**Powerhouse Ultimo Renewal – Concept State Significant Development Application (SSD-32927319)
Response to Further Submissions**

This letter is prepared on behalf of the Applicant for SSD32927319 (Powerhouse Ultimo Renewal) in response to matters raised in relation to the Response to Submissions by government agencies. A detailed response to the matters raised in submission received from the following government agencies is provided in **Attachment 1**:

Attachment 1 – Response to Submissions

7.19 Deep Soil

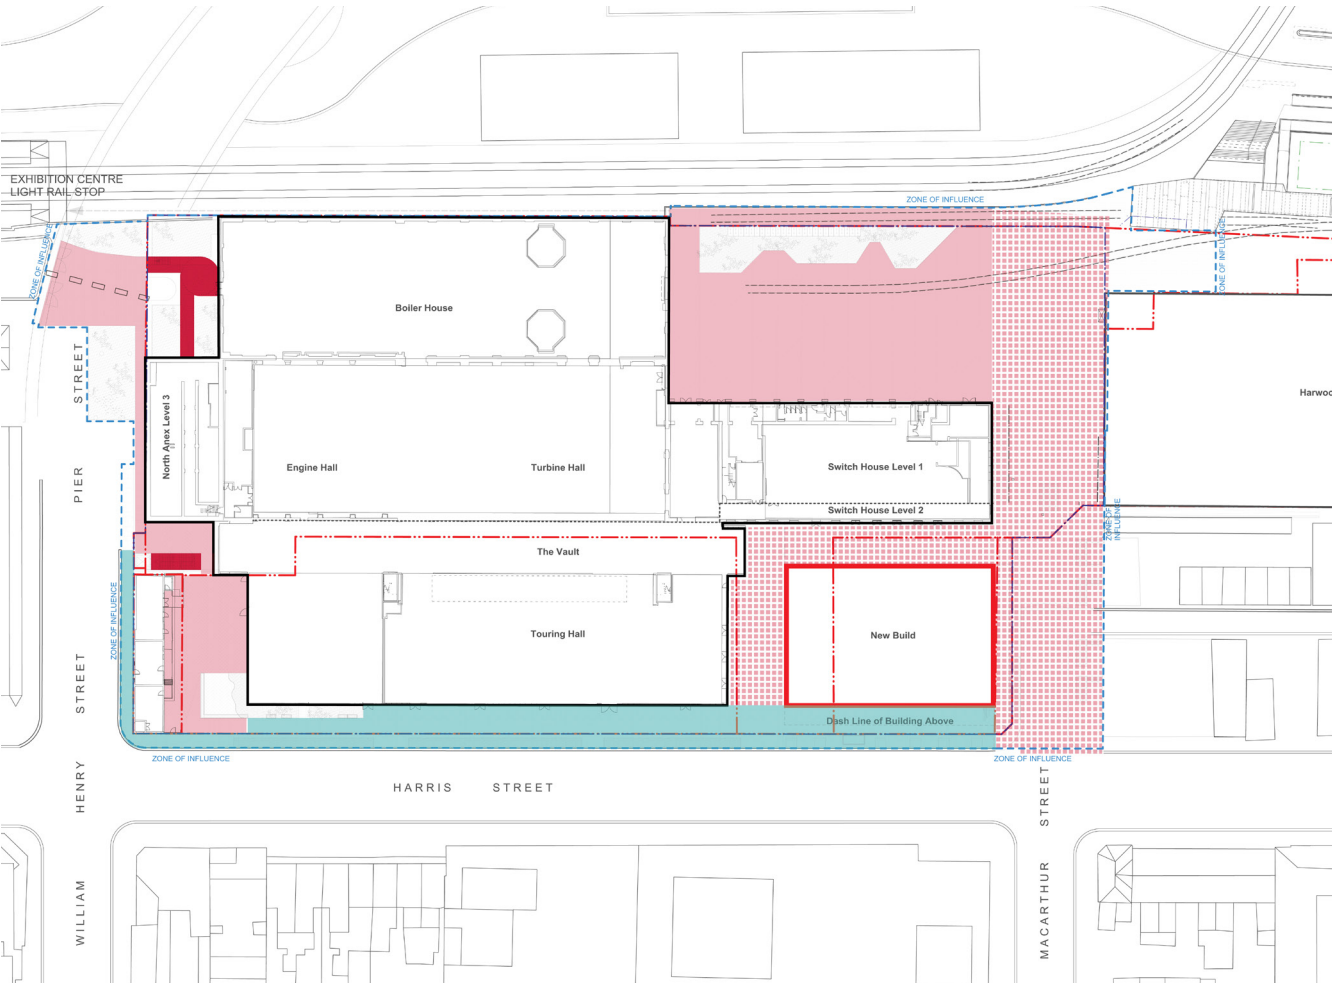
COS -15	<p>The response provided in the RtS in relation to landscaping within the site, deep soil and canopy coverage is considered unsatisfactory and the City's comments and concerns as raised in our previous submission remain.</p>	<p>A commitment for deep soil planting to be at a minimum of 5% has been made as part of the Response to Submissions, which is significantly more than the current 0.18% of deep soil</p>
